**re: Geotechnical Responses to City Comments  
Proposed Residential Development  
1592 Tenth Line Road – Ottawa**  
**to: Oligo Group – Mr. Ketan Dhawan – [ketan.dhawan@olicobuilders.com](mailto:ketan.dhawan@olicobuilders.com)**  
**date:** December 18, 2023  
**file:** PG5632-MEMO.02

## **Geotechnical Comment Responses**

DRAWING:
SITE GRADING PLAN

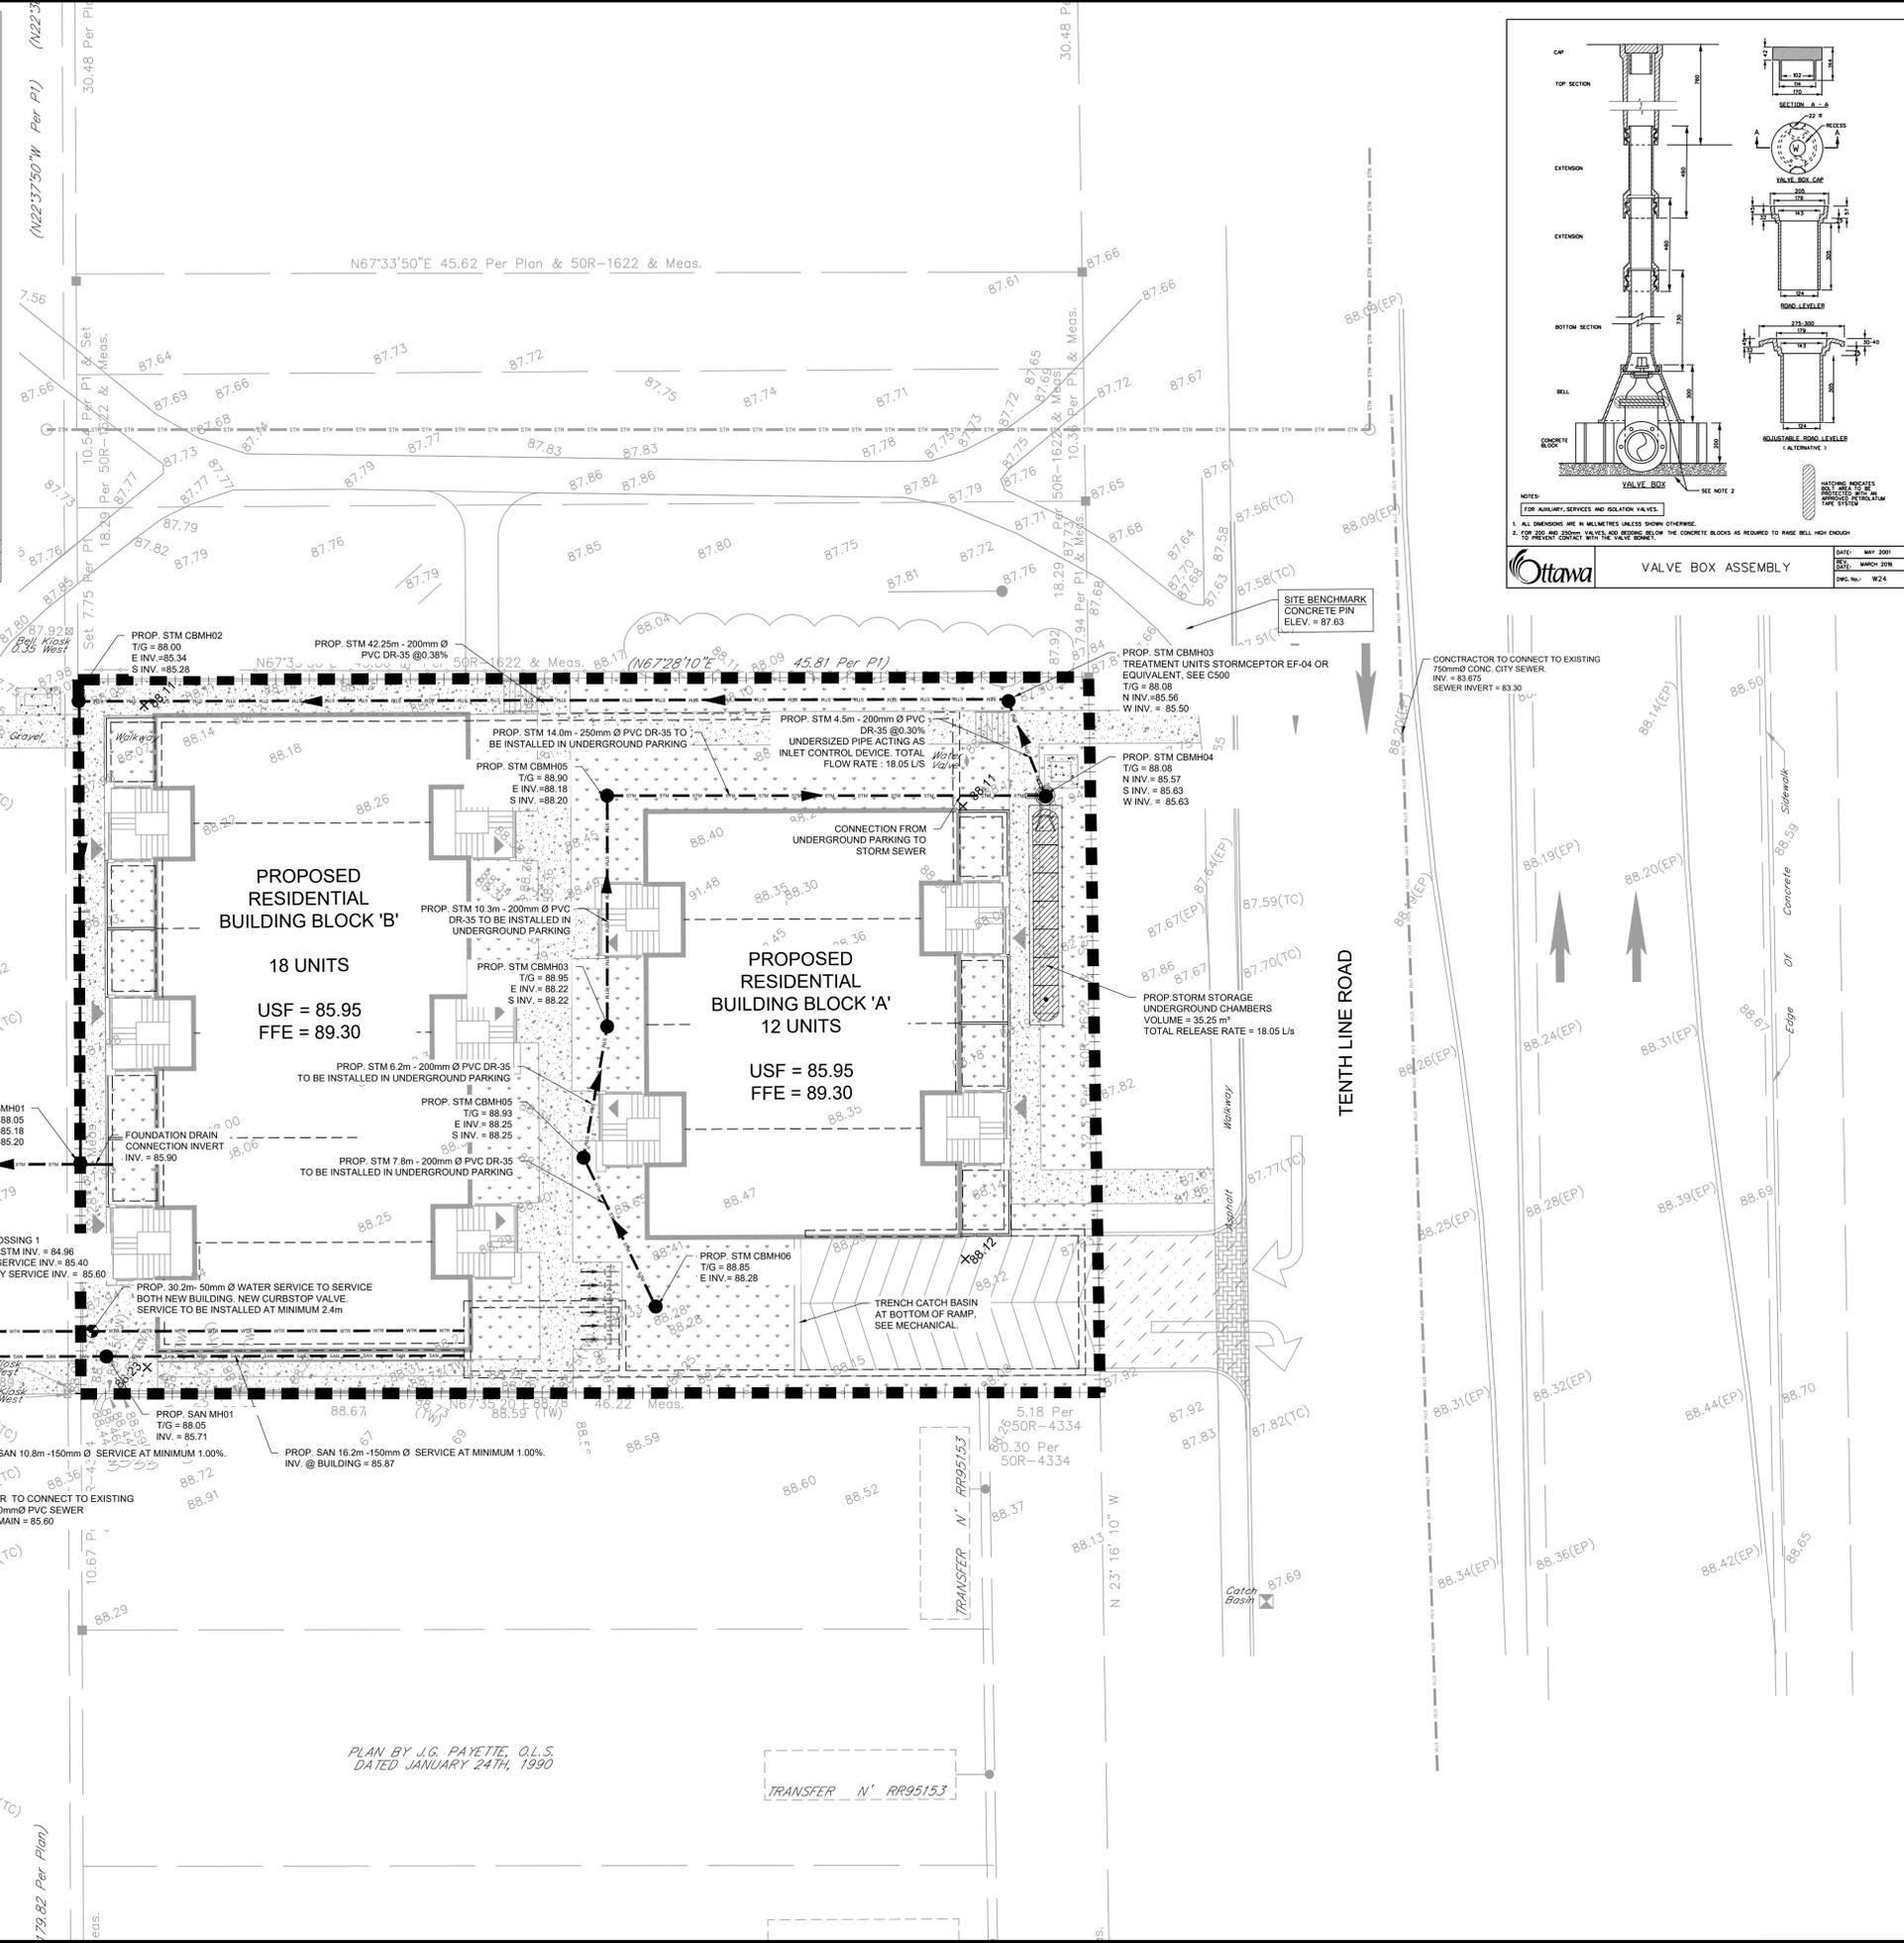
**Comment B2:** *Please provide a signed and sealed memo from the retained geotechnical consultant confirming that the most recent grading, servicing, landscaping design drawings are in conformance with the geotechnical recommendations provided in the geotechnical report.*

**Response:** Paterson has reviewed the most recent grading and servicing plans for the proposed development:

- Site Grading Plan – File No. 522677, Revision 3 dated June 2023 and prepared by Tatham Engineering.

Based on our review, the current grading and servicing plans are in conformance with the recommendations in the Geotechnical Investigation Report. Accordingly, no lightweight fill is required to accommodate the proposed grading at the subject site, nor is insulation required to protect the proposed servicing pipes from the effects of frost action.

Sketch SK1

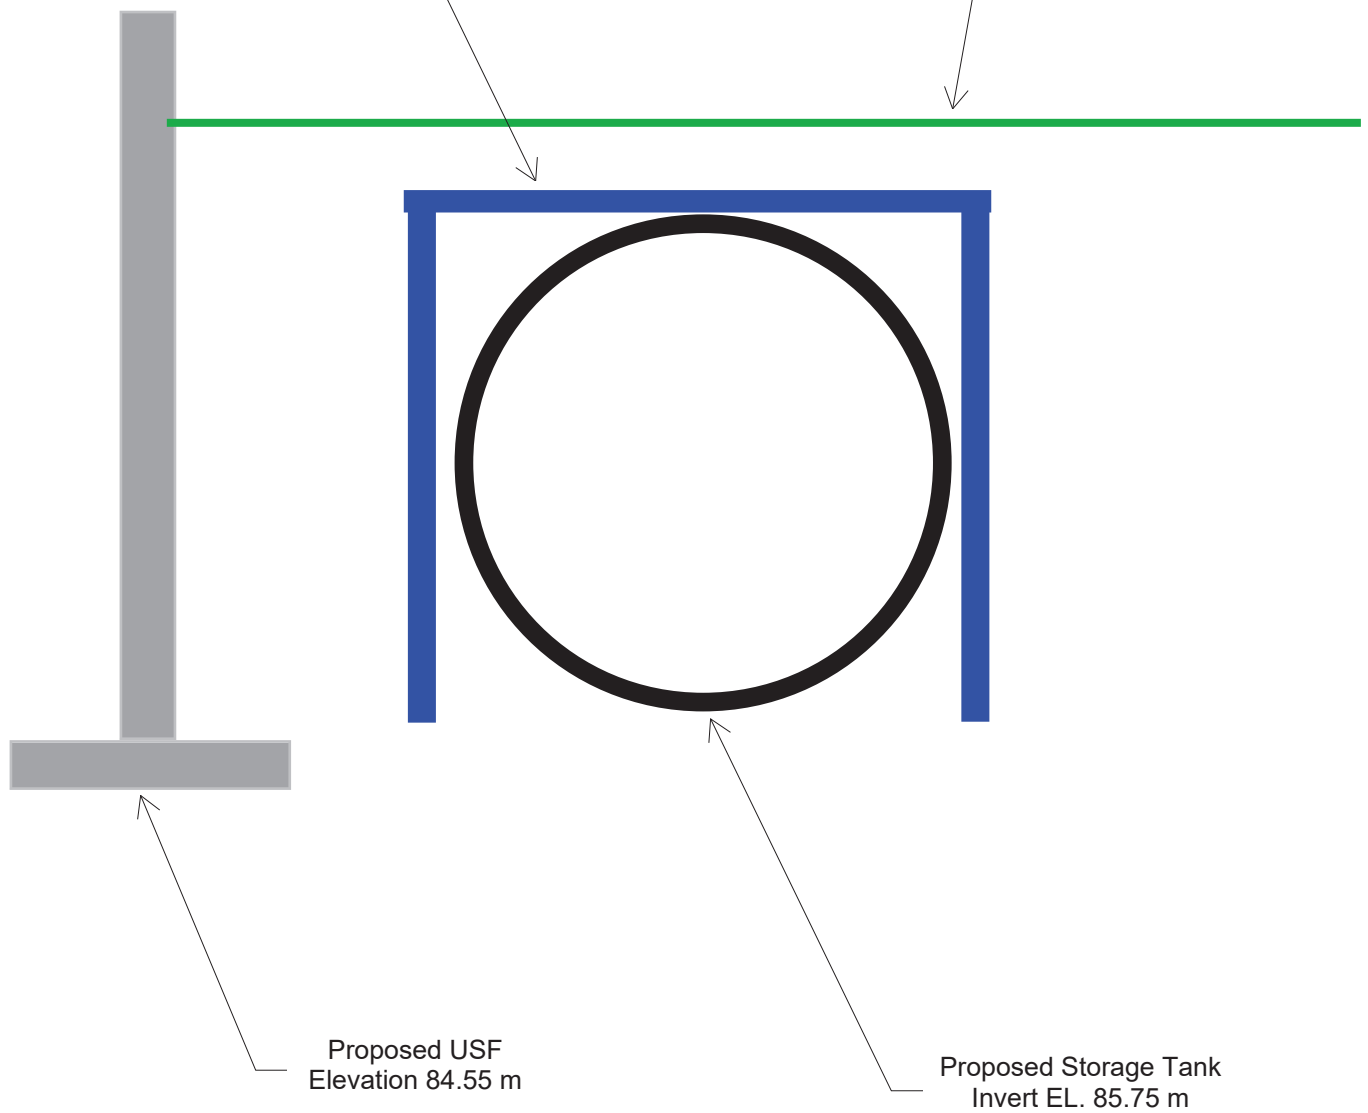
- **Please also add a section in the report to discuss constructability (given close proximity to proposed foundation wall) and suitability of stormwater storage tank proposed for this site as it relates to the geotechnical parameters. Include cross-section and make recommendations related to adequate cover, etc.**

This sub-section also states that there are no issues with the proposed storage tank, from a geotechnical perspective, although insulation will be needed. The insulation details are shown on the cross-section sketch which is provided in Appendix 1 of the updated Geotechnical Investigation Report, referenced above.
